CITY OF ALBUQUERQUE

**Re: Safe House Distilling Co.
616 Gold SW, 87102
30-Day Temporary Certificate of Occupancy
Transportation Development Final Inspection
Engineer's/Architect's Stamp dated 2-12-19 (K14D115)
Certification dated 5-31-19**

SHEET TITLE
TRAFFIC CIRCULATION LAYOUT

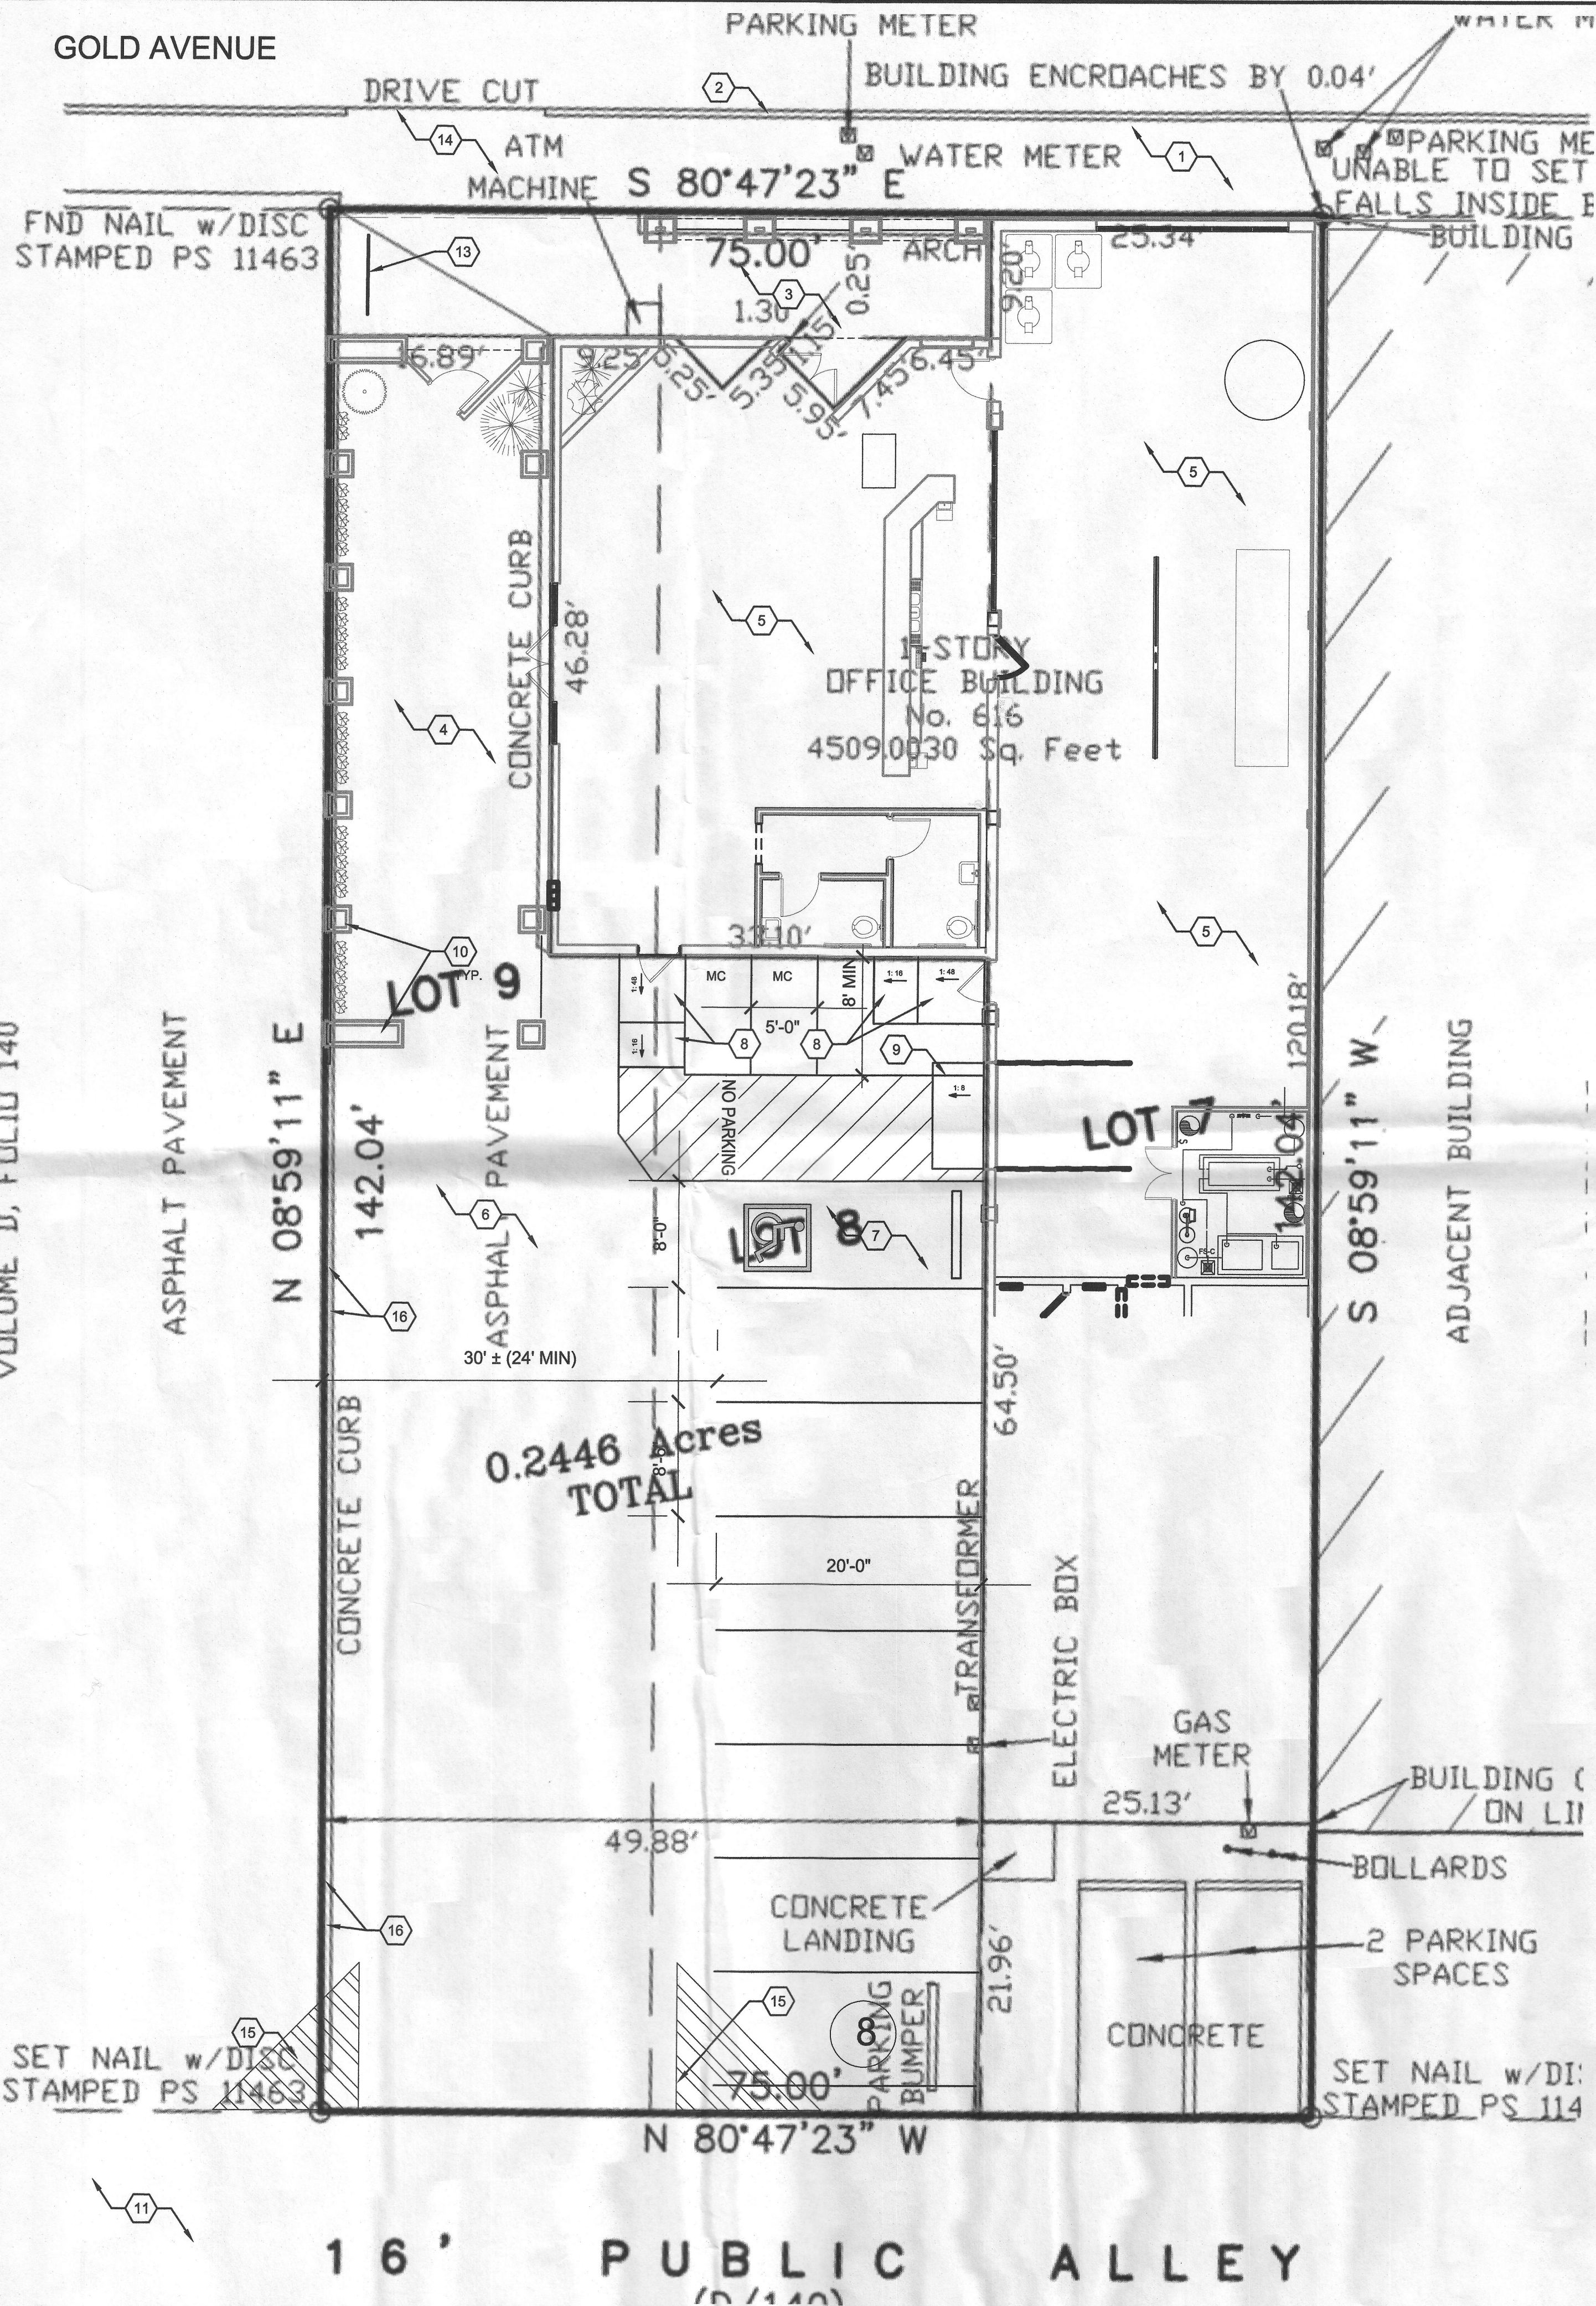
1. Please remove debris behind wheel stop at access aisle. (See attached photo)
2. Please send photos of correction to epgomez@cabq.gov for release of final CO.
